MAJOR PROJECT ASSESSMENT:
Project Application for Stage 1-
Residential Development
61 Mobbs Lane, Epping
MP 08_0257

**Director-General's
Environmental Assessment Report
Section 75I of the
*Environmental Planning and Assessment
Act 1979***

August 2010

Section A-A Building 4 +5
1:200

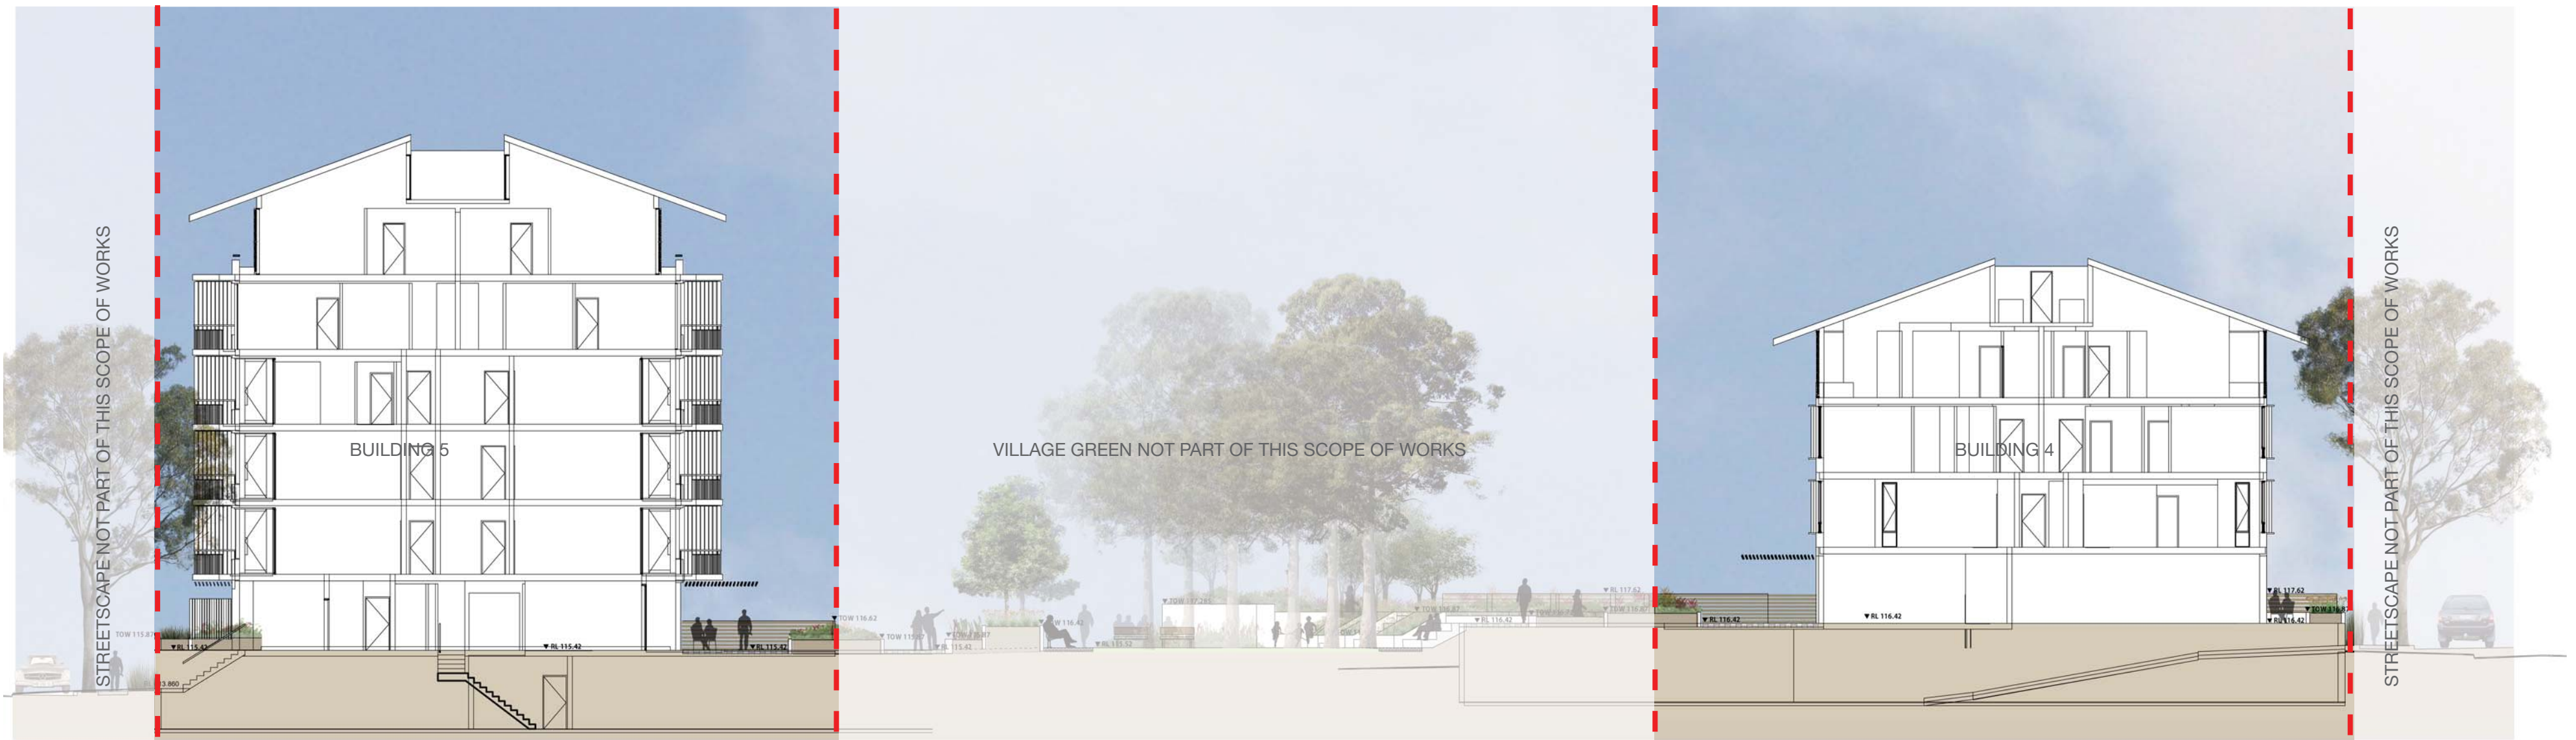
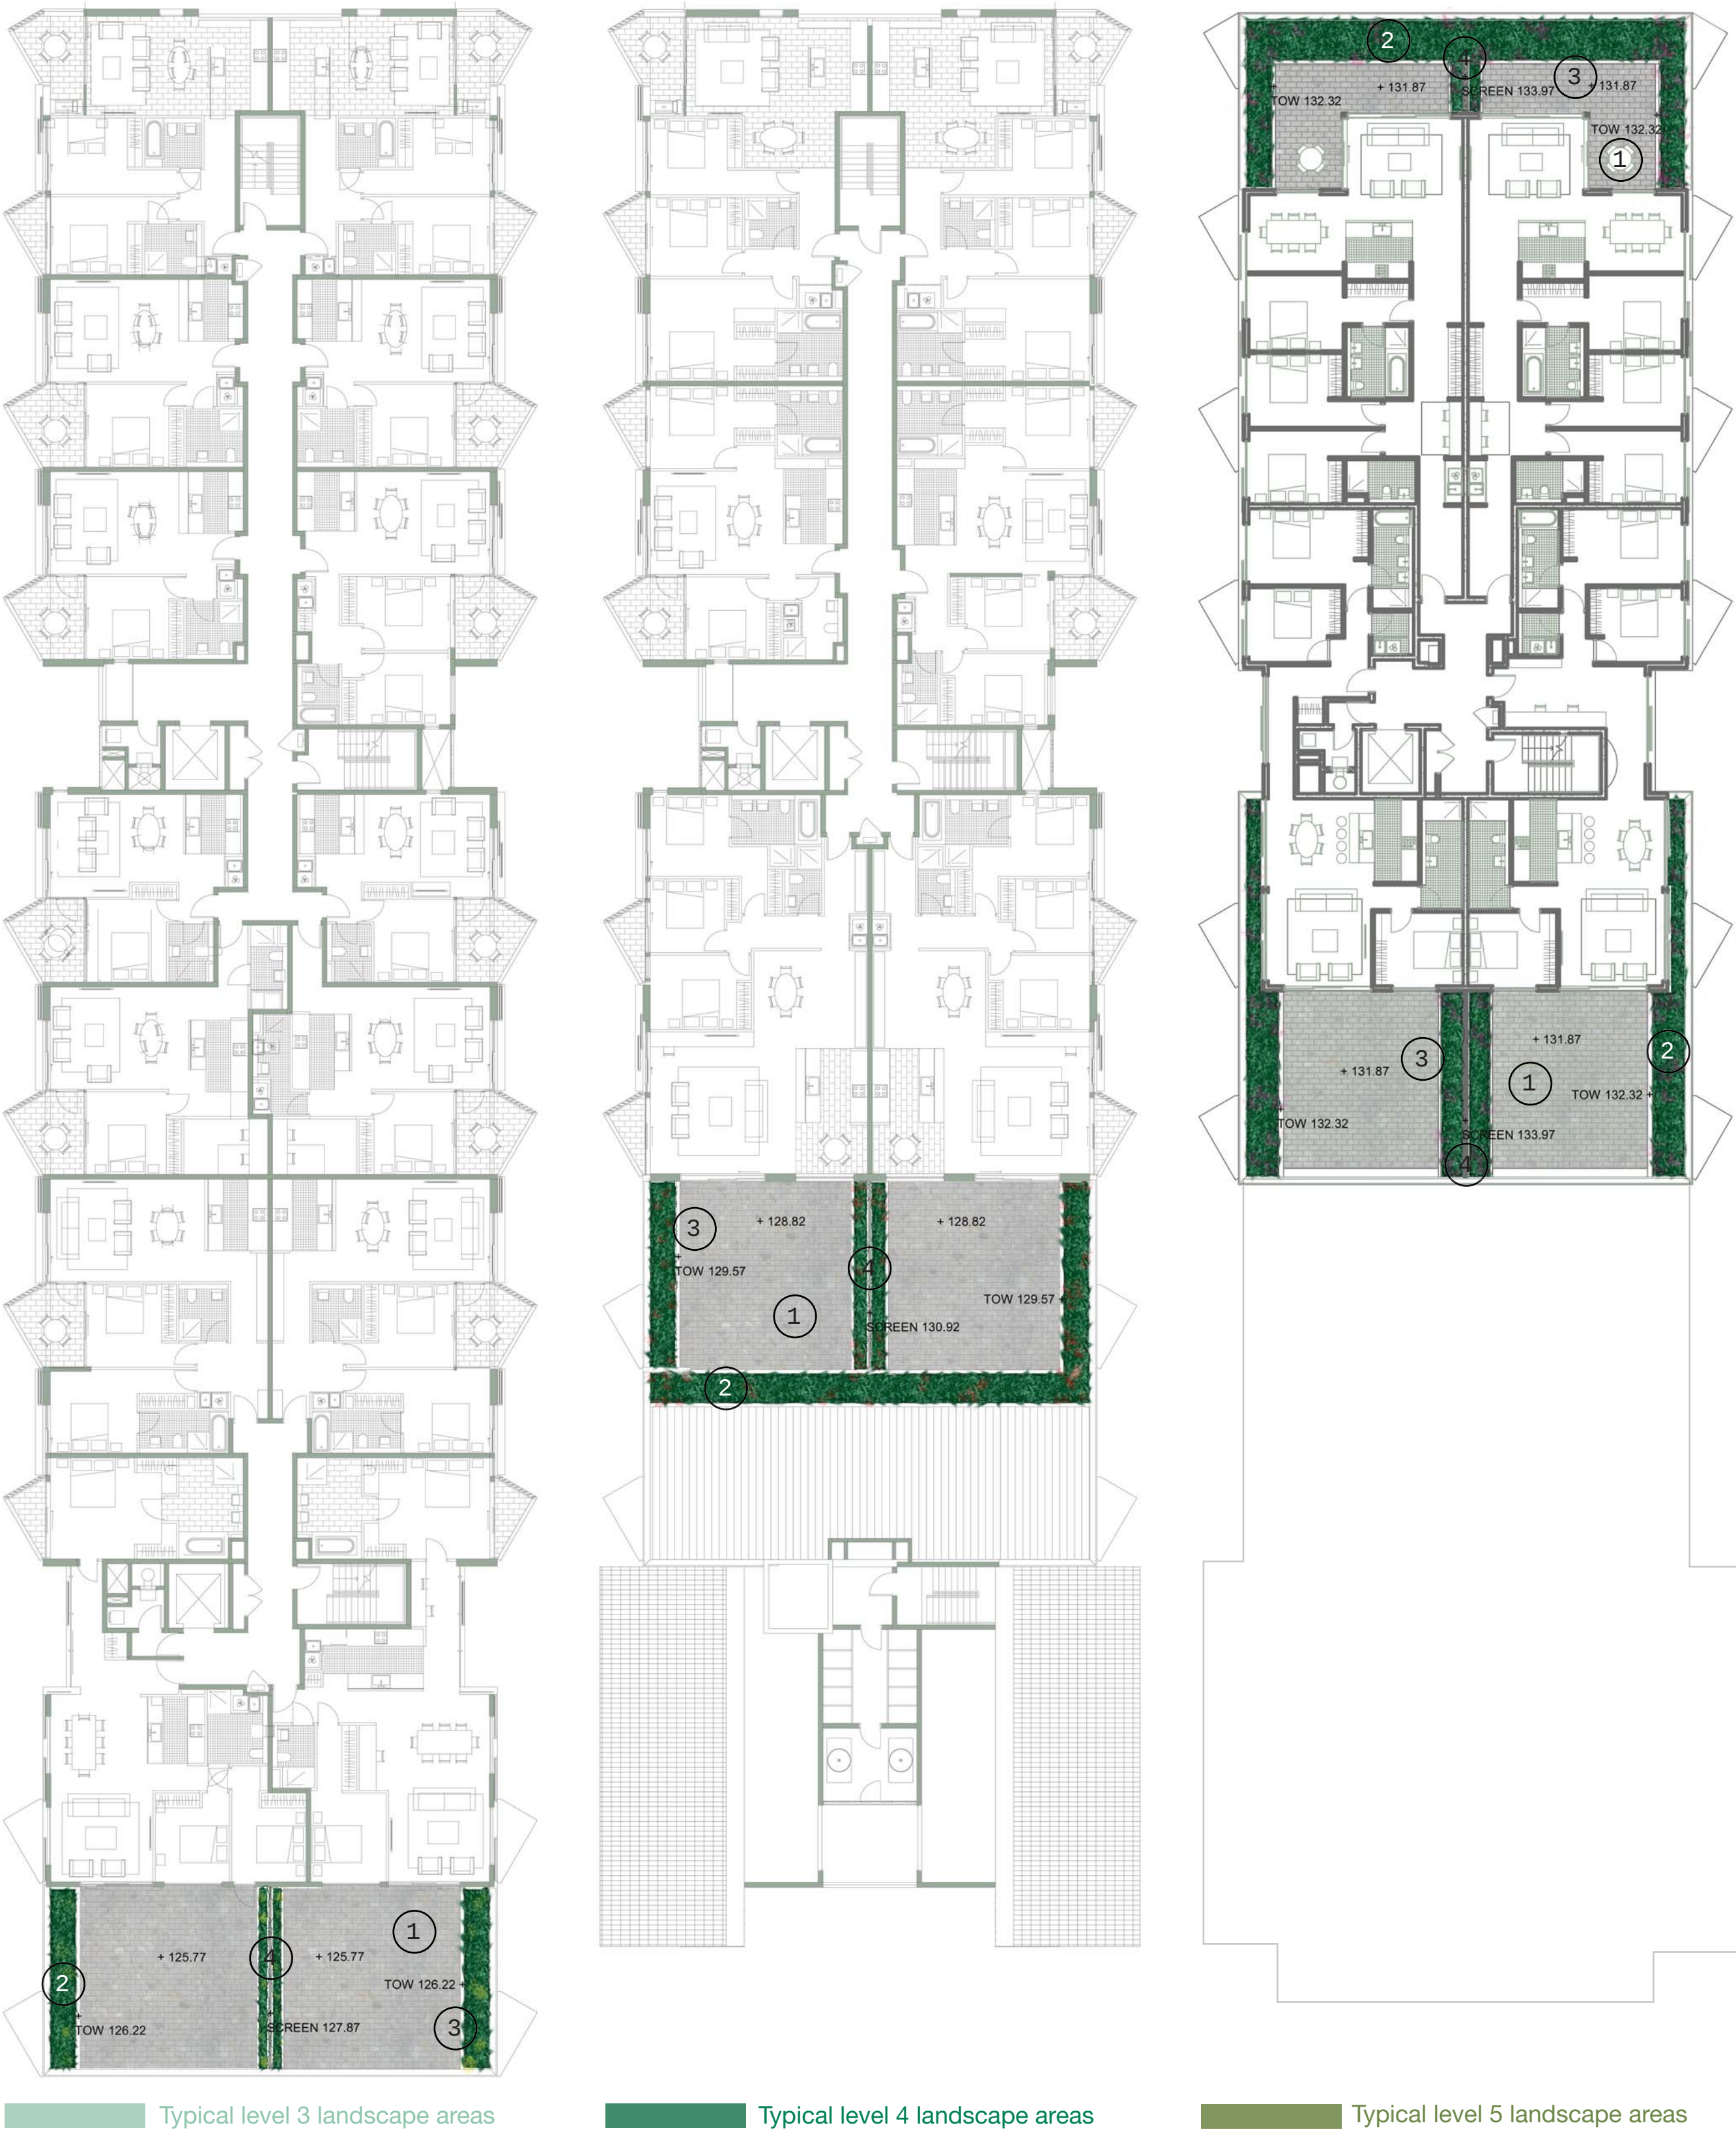
The proposed 2.8m high screen walls surrounding the roof top plant are considered excessive. Therefore a condition is recommended in **Appendix G**, requiring the screen walls to be replaced with louvers with a maximum height of 1.4m above finished roof level. This will minimise the bulk of the roof top plant when viewed from surrounding areas.
